**REPORT ON SUBMISSIONS RECEIVED
DURING PUBLIC EXHIBITION**

**USED OIL TRANSFER STATION PART 3A
MAJOR PROJECT**

81-85 CHRISTIE STREET, ST MARYS

December 2006

8. Drawings of Fire Services Layout

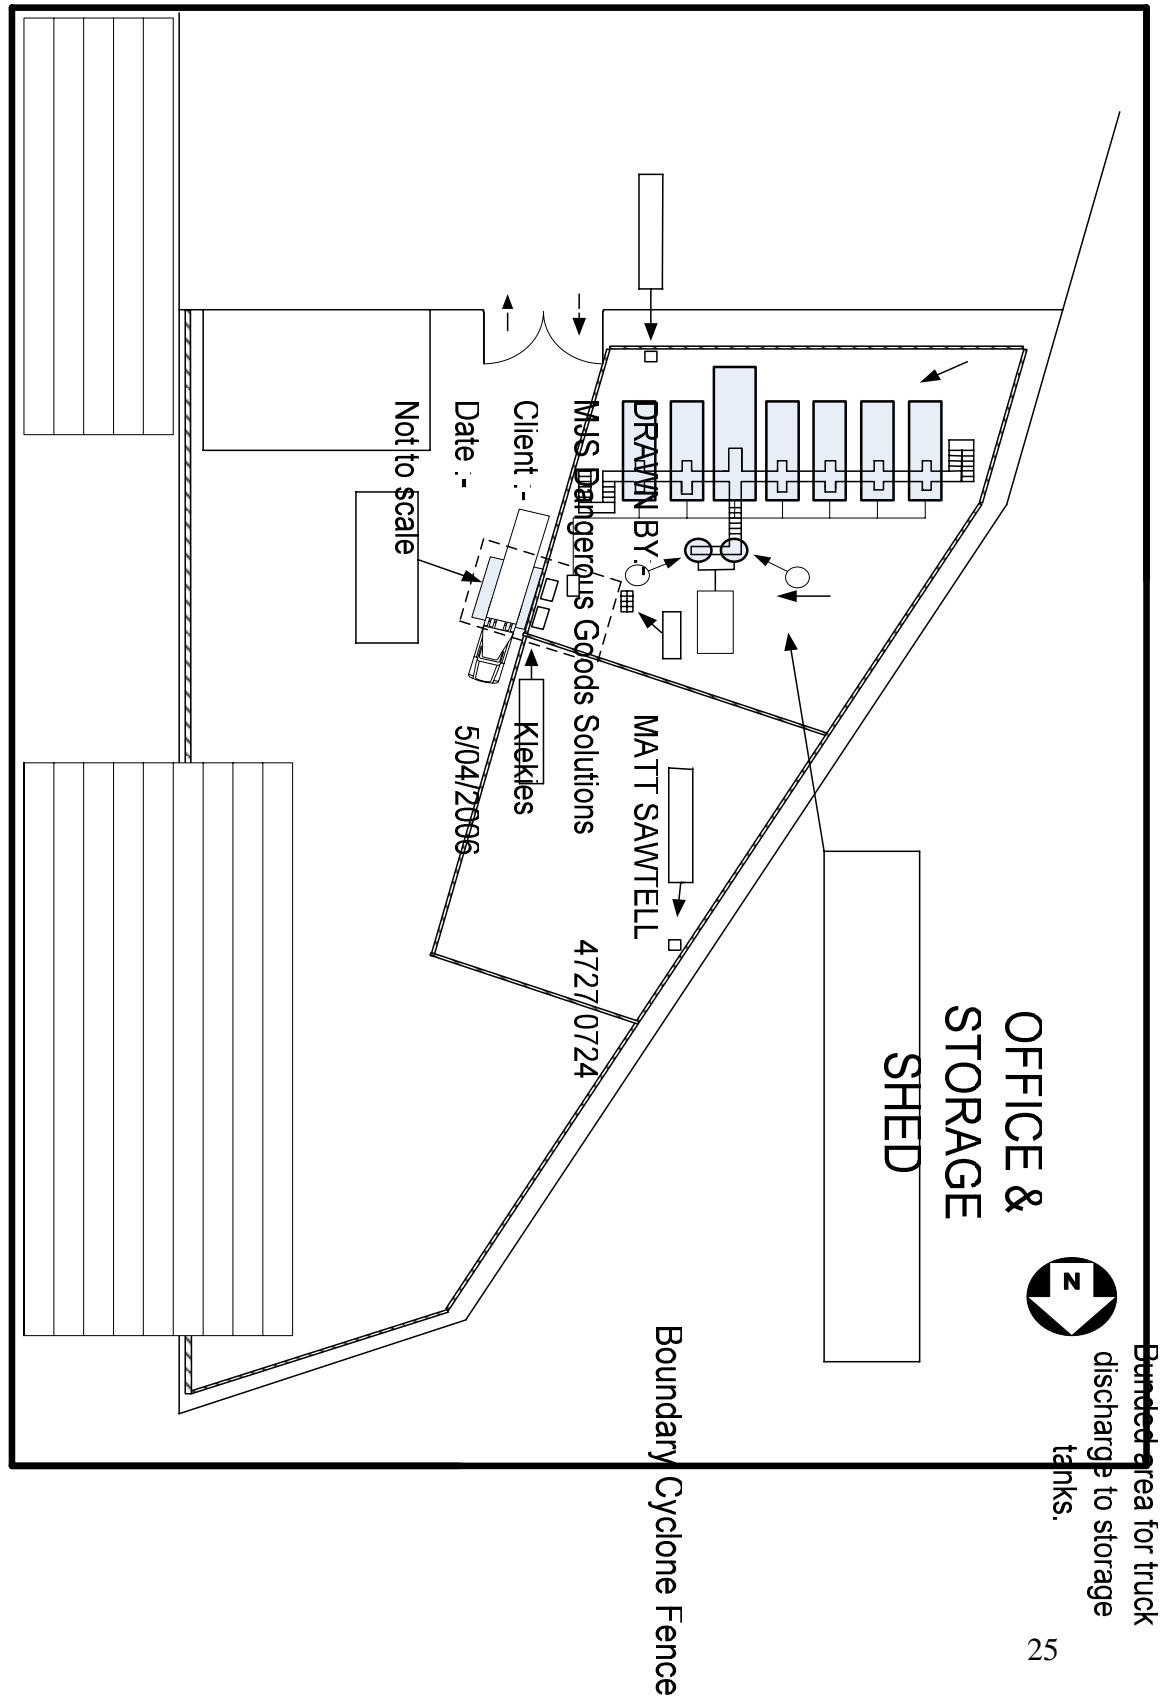
- 1. There is a lack of detail in relation to the sites fire hydrant system. The EA and FSS state that local NSWFB station where consulted regarding hydrant location. The EA and HA state two hydrants are to be provided, the FSS states up to four hydrants are provided whilst indicates one hydrant on the site plan. The FSS does not contain any calculations to indicate hydraulic adequacy of the system;*
- 2. The NSWFB recommends that a hydrant system complying with Australian Standard AS 2419.1 be provided for the proposed warehouse/office, and the tank farm as per Clause 3.3 of that standard;*
- 3. Site plans in all the submitted documents indicate either one or two hydrants located within the bunded compound, the NSWFB recommends hydrants be located outside the bunded area.*

The Hazard Analysis Report and specifically the Fire Safety Study prepared by M.J.S Dangerous Goods Solutions has been reviewed and amended. In regard to the proposed hydrants the amended Fire Safety Study provides:

A fire hydrant will be located outside the bunded area of the tank farm and another located halfway down the site close to the fence line on the southern boundary. A third hydrant will be located outside the office/warehouse. These hydrants will be installed as per AS2419.1 2005, "Fire Hydrant Installations".

The site plan accompanying the Fire Safety Study accurately depicts the proposed hydrants. The Statement of Commitments will be amended to reflect these changes.
